Application No: EP/53/22/HH
Site Address: 38 Hillview Crescent East Preston BN16 1RQ
Description of works: Hip to gable loft conversion with rear dormer.

Thank you for your internet representation made on 16th June 2022 which has been recorded as an objection with the comments as follows:

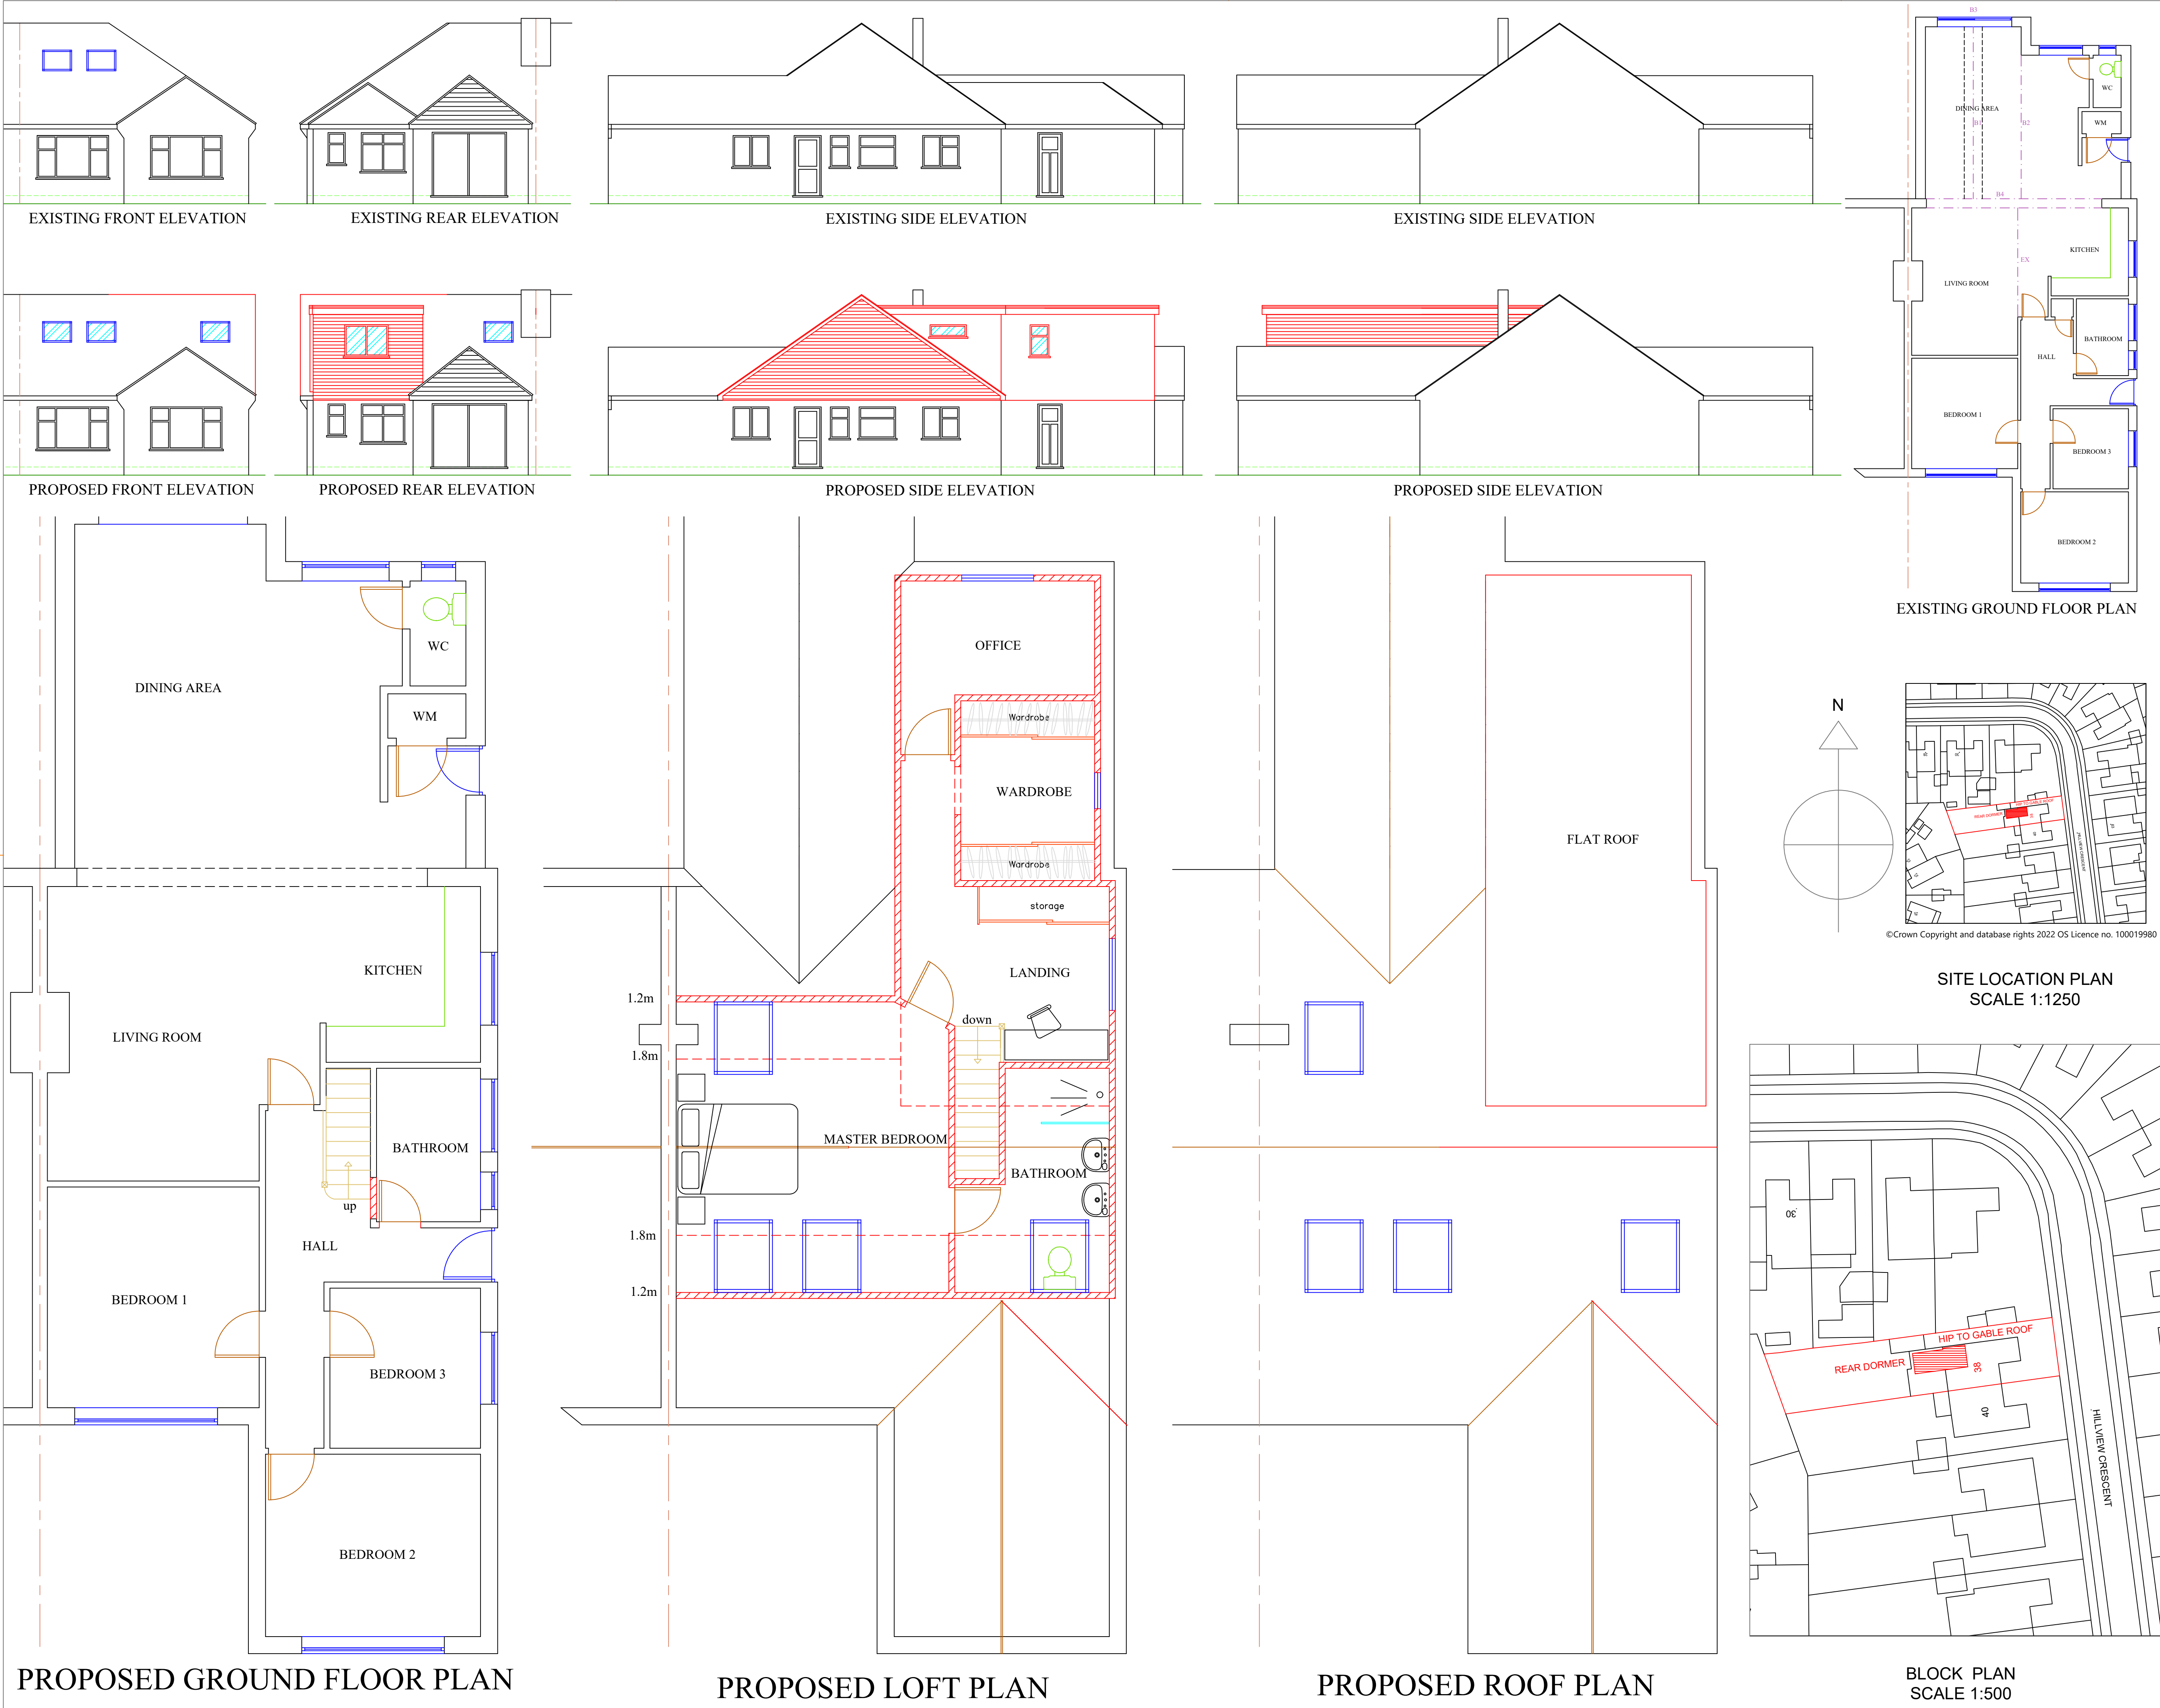
I write as Chairman of the East Preston & Kingston Preservation Society to object to this application. The hip to gable loft conversion would detract from the symmetry of this pair of small bungalows, to the detriment of the street scene, conflicting with Policies li (especially with regard to paras. 4.16 and 4.18) and 3ii of the East Preston Neighbourhood Plan. The proposed two-storey "dormer" extension would also be overbearing on neighbouring properties, negatively impacting them in terms of privacy and overshadowing, contrary to Policy M of the Arun Design Guide.
